From: Bryan Butcher <[REDACTED]>
Sent: 11 October 2019 17:37
To: Amber Willard
Subject: Re: fp/182/19/hh

I am just writing up the application at FP/182/19/HH at 3 The Loop.

sheet 2 of 3

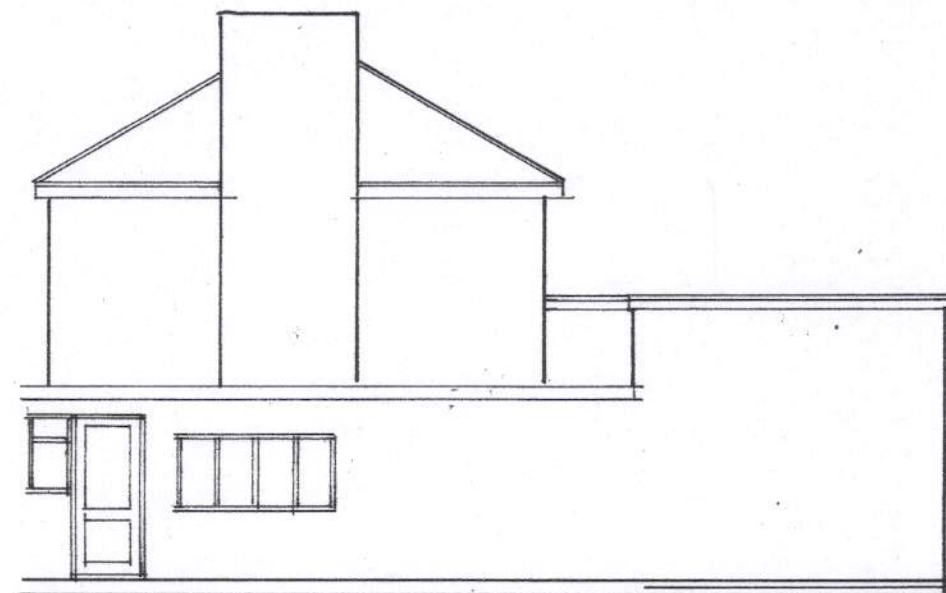
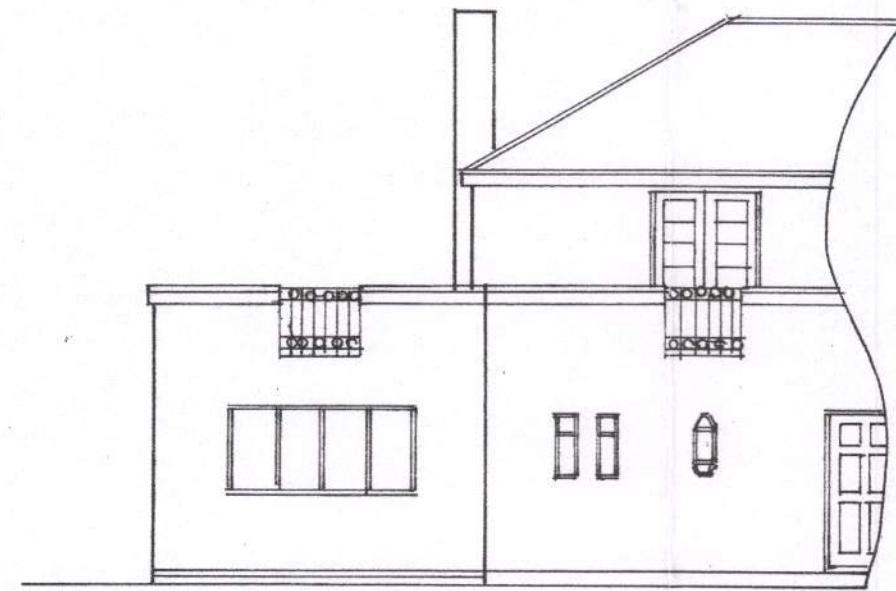
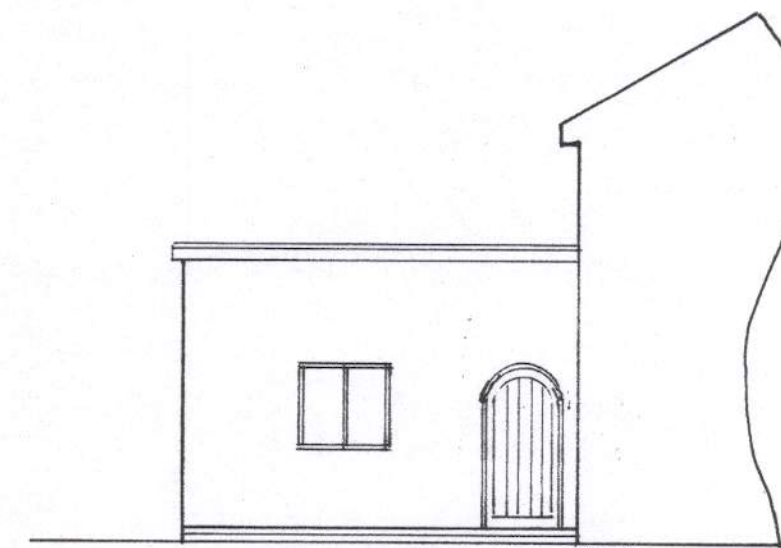
Do you know if the extension is intended to be used a balcony as they have the railings in place, although it is not clear if there is access.

There is an existing balcony at the front but the new is not to be used as one.
The railings are to replicate the existing elevation
